Application Reference Number:		2025/0063	
Application Type:		Householder	
Proposal Description:		Erection of detached double garage	
Location:		27 Low Folds, Monk Bretton, Barnsley, S71 5SB	
Applicant:		Mr Ben Hall	
Third-party representations:	One	Parish:	None
		Ward:	Cudworth

This planning application has been submitted by Mr Ben Hall and seeks householder planning permission for the erection of a detached double garage to the front/side of the property.

BLOCK PLAN
SCALE 1:200 AT A3

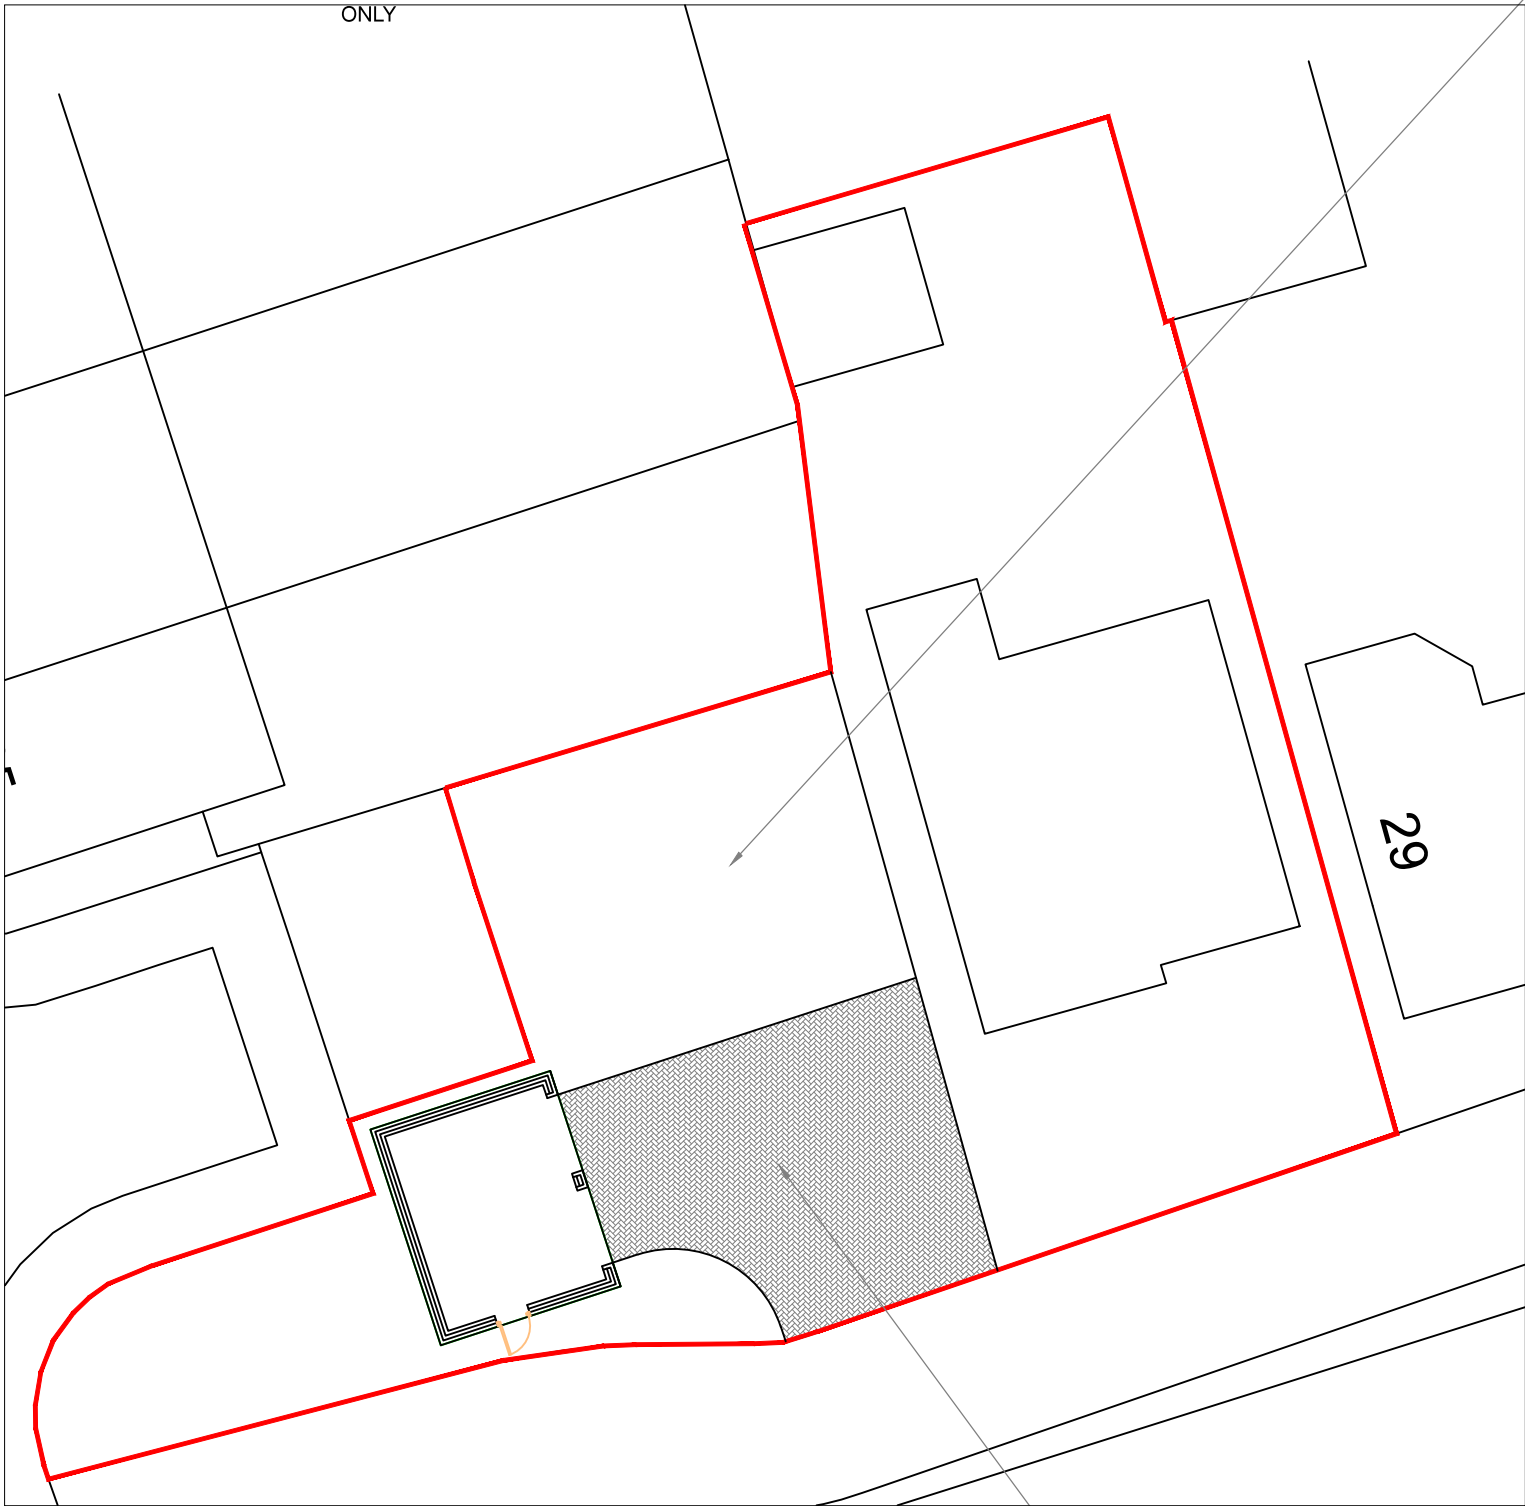
The SPD states that *“detached garages should relate sympathetically to the main dwelling in style, proportions and external finishes. In most cases, it will not be appropriate for a garage to be sited between the house and the road”*. In this case the garage is sited to the side (southwest) of the dwelling and slightly forward the principle elevation of the dwelling. In this circumstance this is acceptable because the garage has to be positioned here to avoid a drainage easement that runs to the side of the dwelling where a garage would be more traditionally placed. It is not possible to locate the garage closer to the dwelling whilst avoiding this.

This will have an impact on the street scene however the garage will be viewed in context of the dwelling from most viewpoints. The addition of a permeable driveway also retains the link between the two. Also, additional landscaping to further screen the garage will be conditioned to a planning approval. The garage is restrained in height and set adjacent to a parking area.

PROPOSED ELEVATIONS

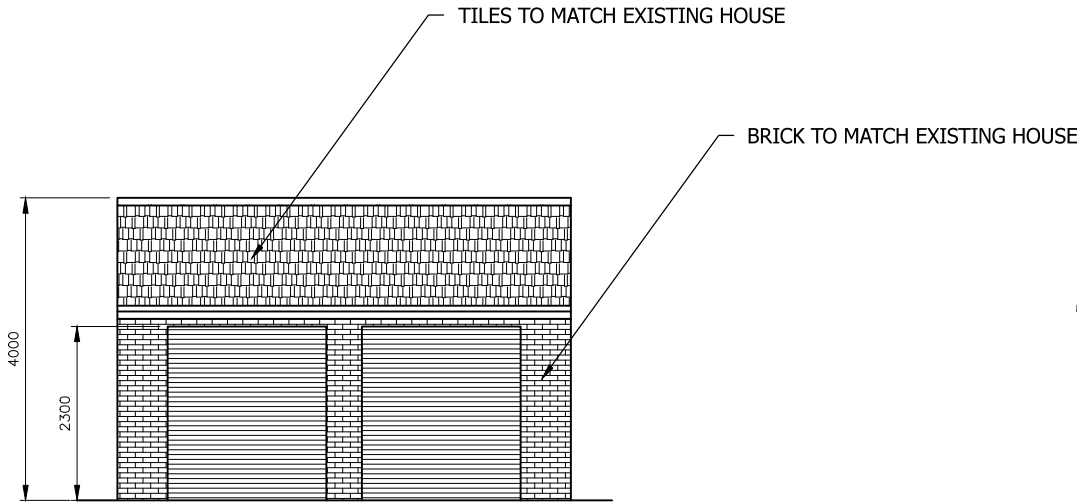
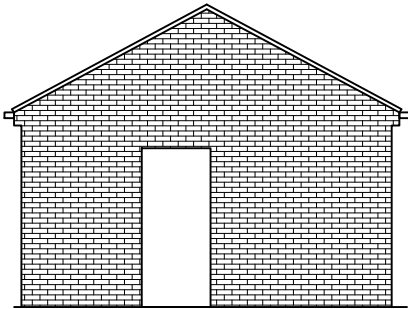
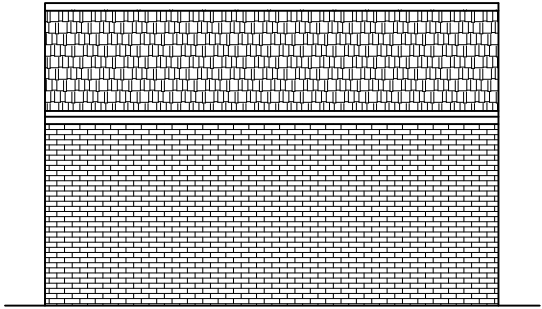
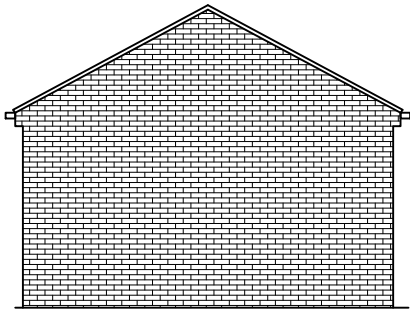
The SPD states that *“detached garages should be single storey structures and the eaves height should not normally exceed 2.5 meters from ground level”*. The proposed garage has a pitched roof with a maximum height of 4 metres and an eaves height 2.4 metres which is in accordance with the above recommendation. This weighs significantly in favour of the proposal.

The SPD states that *“materials should normally be of the same type, colour and texture to the existing house or as close a match as possible”*. In this case, the proposed materials will be matching brickwork and roof tiles to the dwelling which is therefore acceptable. The garage utilises a pitched roof which is akin to the existing dwelling's pitched roof and therefore acceptable. This weighs significantly in favour of the proposal.
